WRITTEN REPRESENTATION

East Pye Solar — Planning Inspectorate Reference EN0110014

Submitted by: Mr. Stuart Shearer & Mrs [REDACTED] Shearer – Interested Parties

Date: 10th September 2026

Sources: Esri, TomTom, Garmin, FAO, NOAA, USGS, © OpenStreetMap contributors, and the GIS User Community

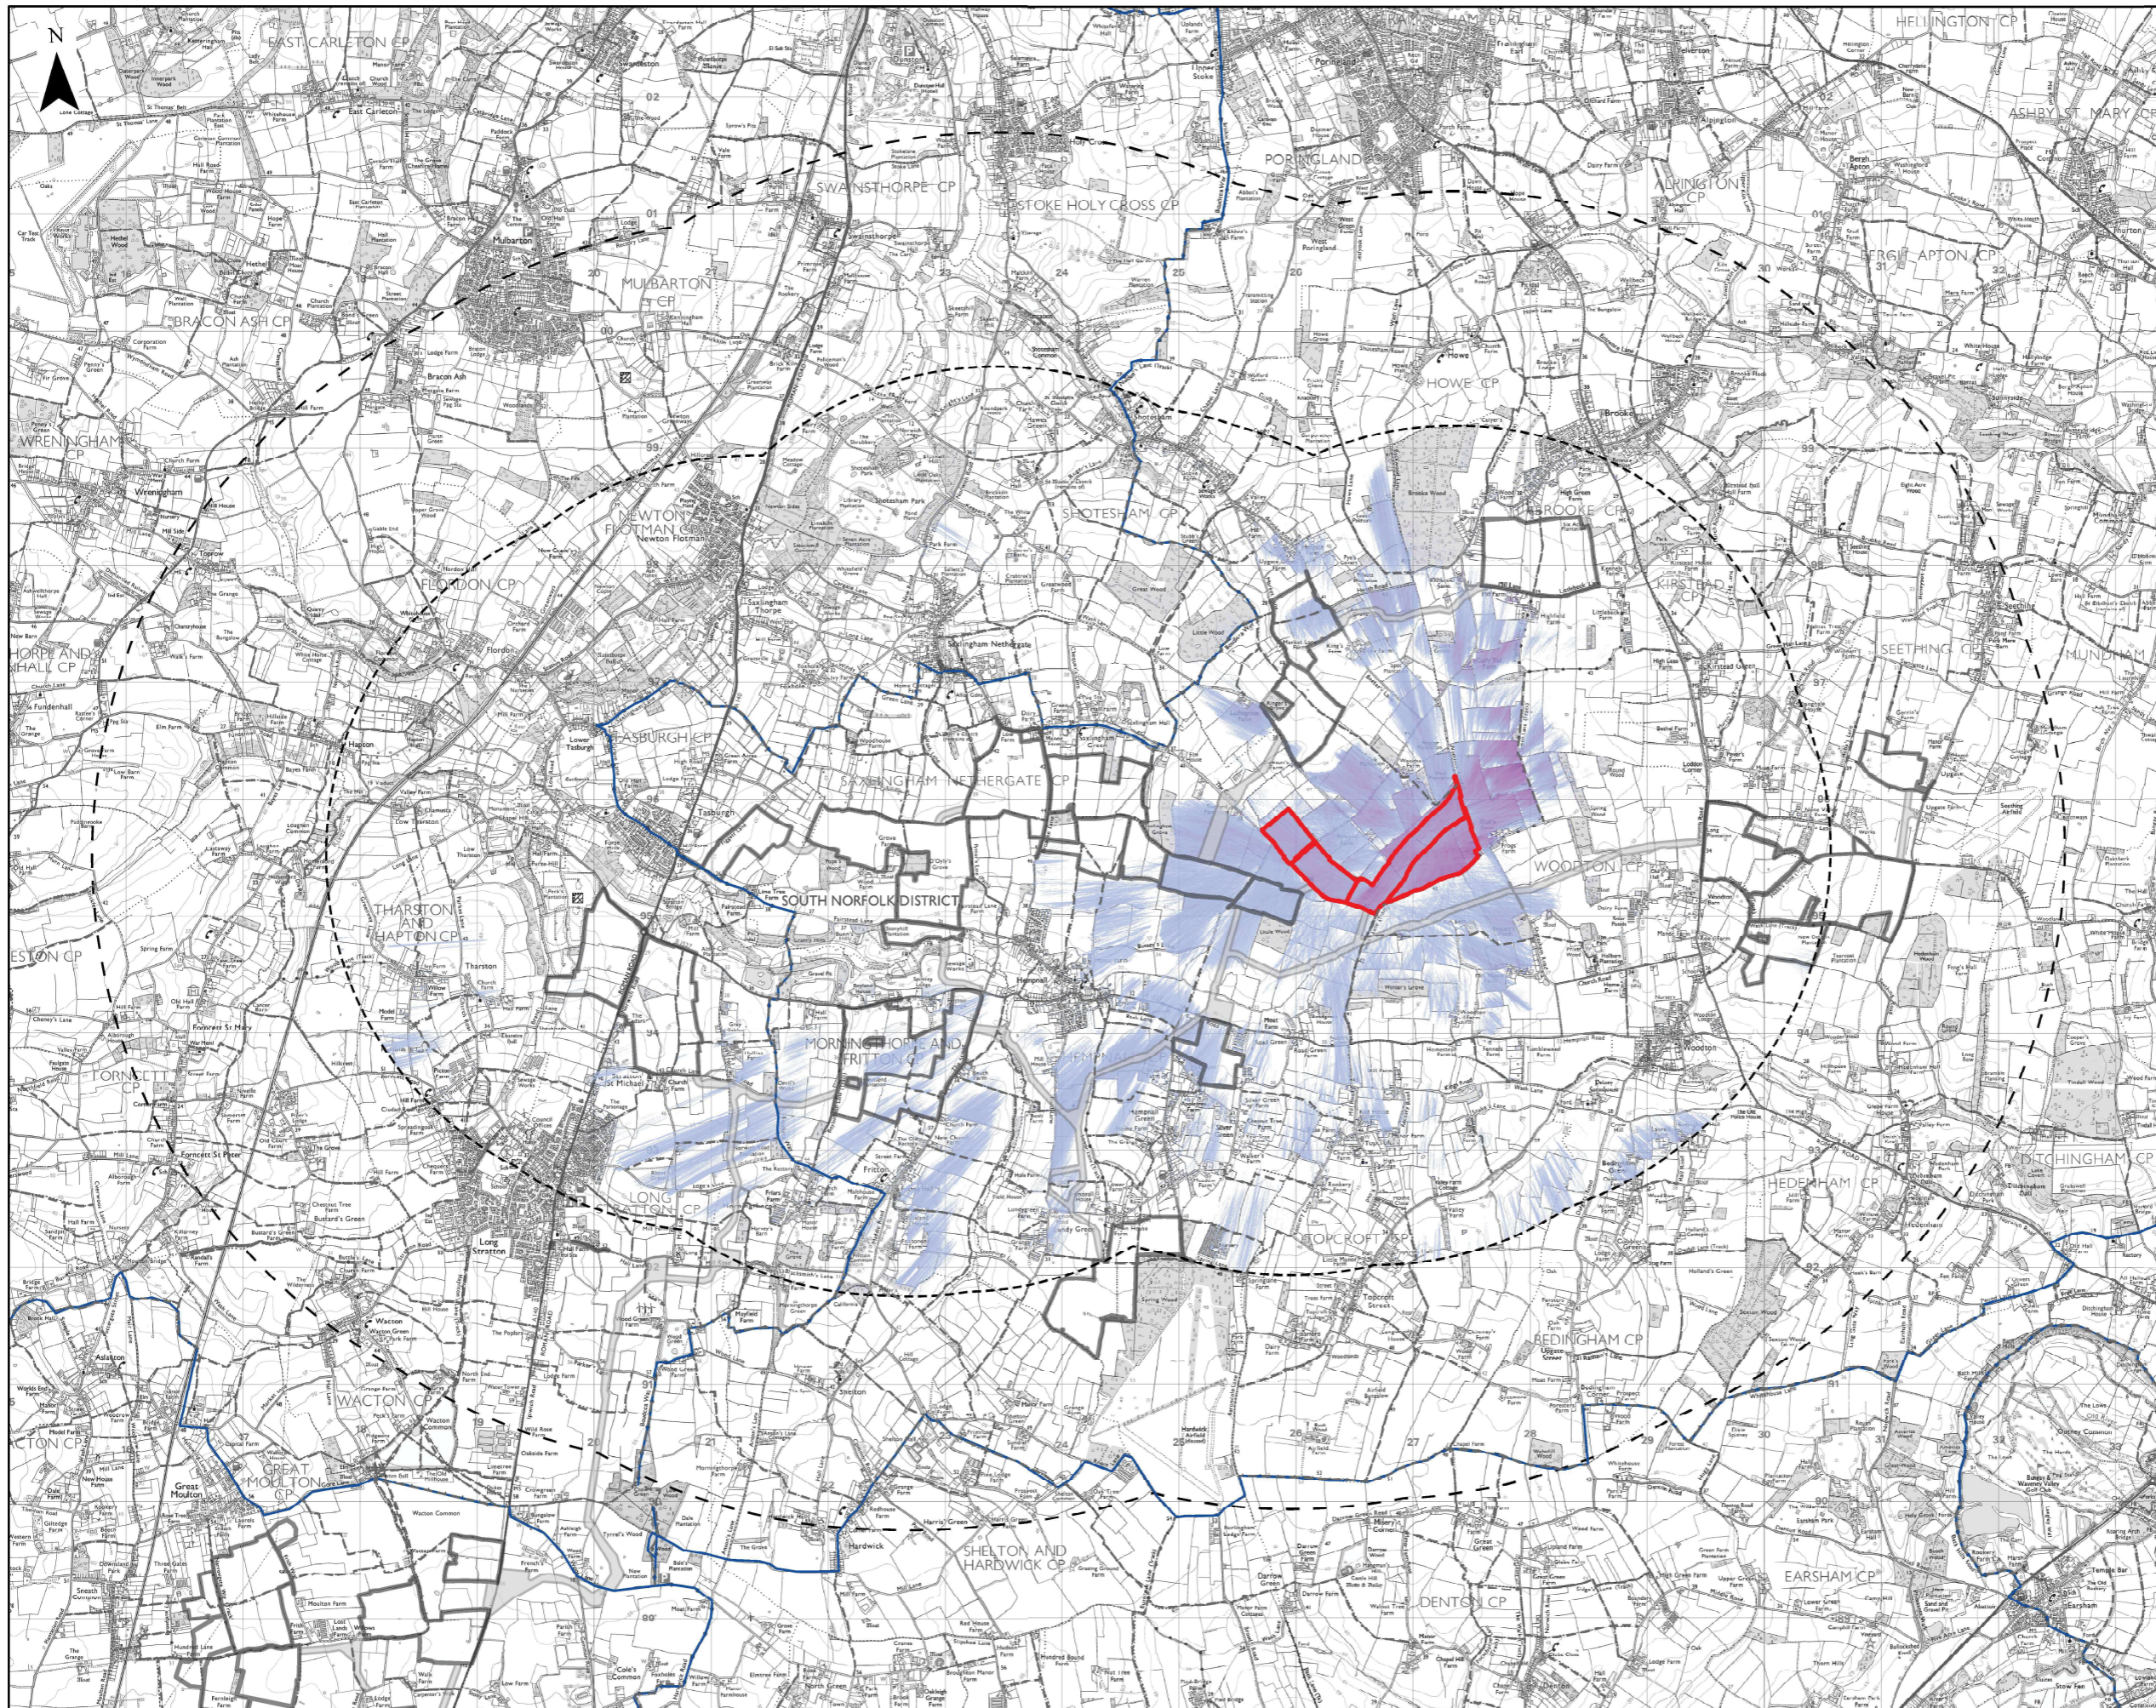
2.12 The Planning Inspectorate's Scoping Opinion (noted in Table 7.1 of ES Chapter 7) specifically directed the Applicant that the ES should assess potential effects on views and visual amenity within the ZTV where significant effects are likely. We request that the Examining Authority requires the Applicant to confirm whether the Property falls within the ZTV for Site 8 (Figure 7.5.4) and Site 7 (Figure 7.5.5) and, if so, to explain why it has not been assessed as a named residential receptor viewpoint.

Figure 11.6: Likely and Suitable Routes to the Scheme
 Sites 7, 8 and 9
 Revision A

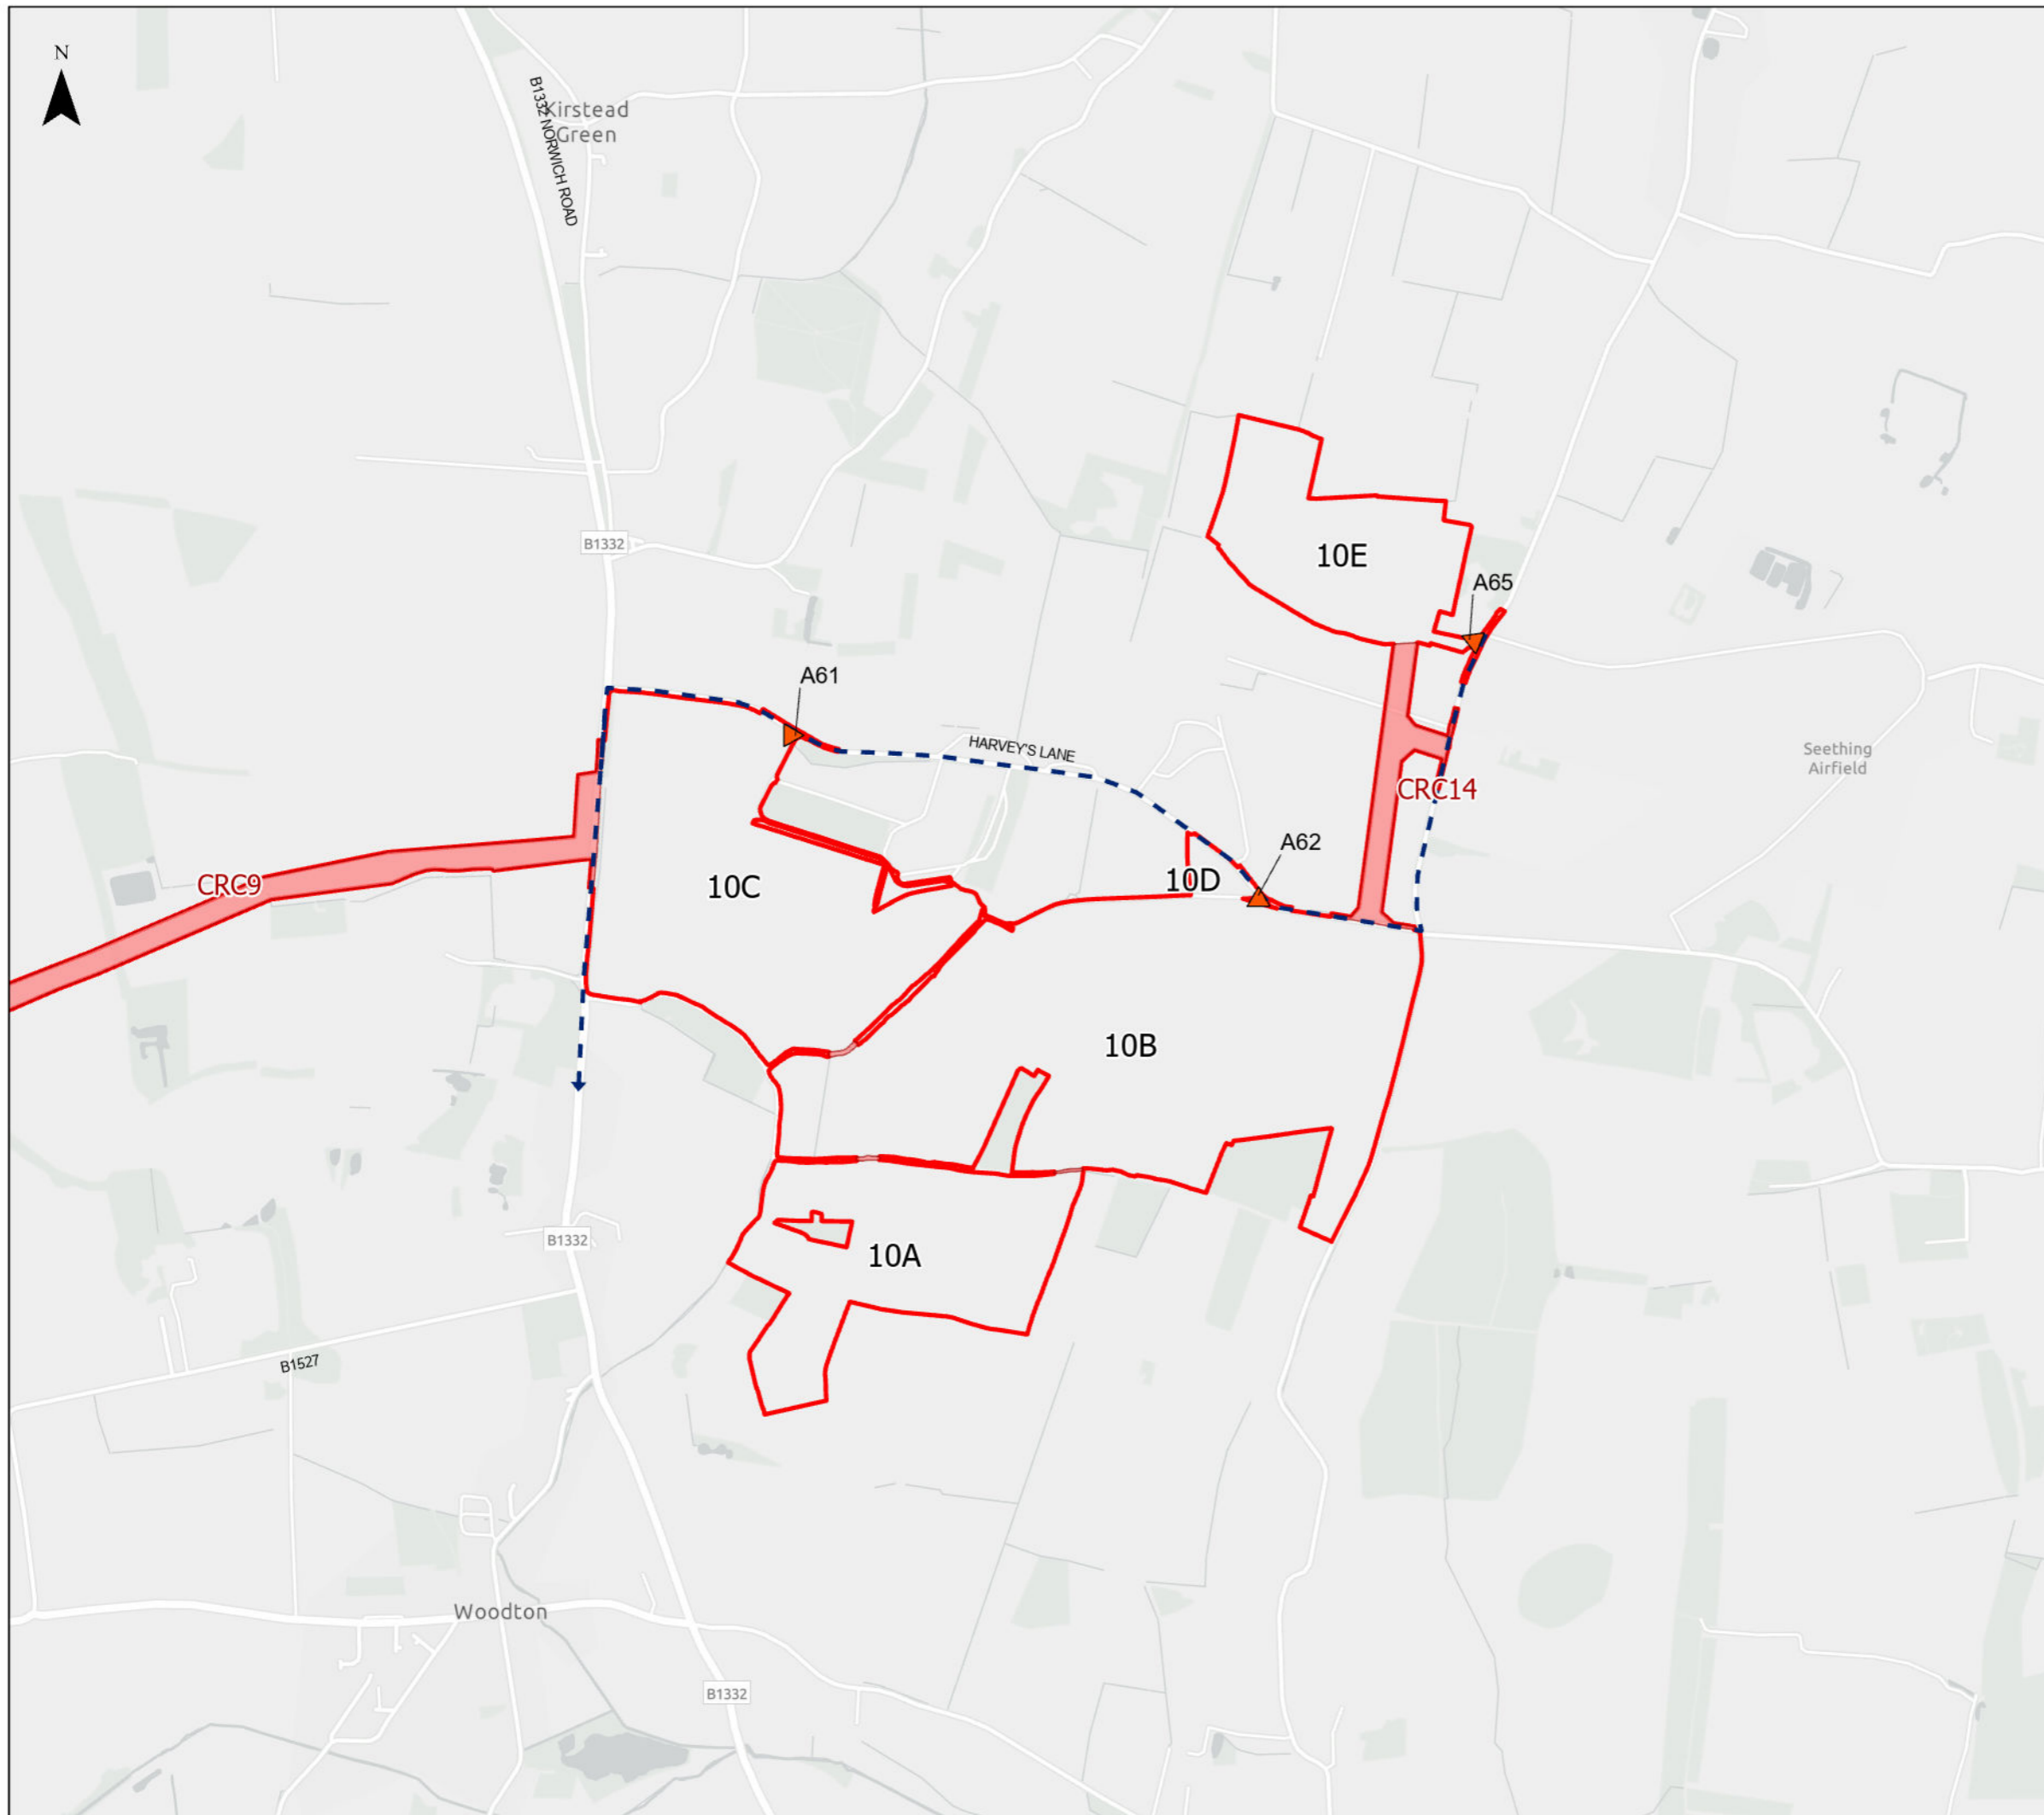
11.1 The Outline Construction Traffic Management Plan (APP/7.6) identifies that Abnormal Indivisible Load (AIL) movements for the transformer serving Sub-Site 7F will be routed via The Street, Saxlingham Nethergate. To accommodate these abnormal loads, which may be up to 5.5 metres wide, the 4.5 metre-wide street through the village would need to be widened.

11.2 The proposed widening would require the demolition of an 18th century wall at the Old Rectory and the expansion of the carriageway onto part of the triangular parcel of land on which Saxlingham Nethergate's Grade II listed war memorial stands. This is an extraordinary and wholly unacceptable proposal.

11.3 This directly contradicts the stated objective of the Outline CTMP that construction vehicle routes have been selected with the principal aim of avoiding routing vehicles through local villages, wherever practicable, including Saxlingham Nethergate. The AIL route as proposed does the precise opposite — it routes the largest and most disruptive vehicles directly through the village and requires the destruction of heritage fabric to do so.

11.5 We request that the Examining Authority requires the Applicant to demonstrate that no viable alternative AIL route exists that avoids The Street in Saxlingham Nethergate and eliminates harm to the Grade II listed war memorial and the 18th century wall at the Old Rectory.
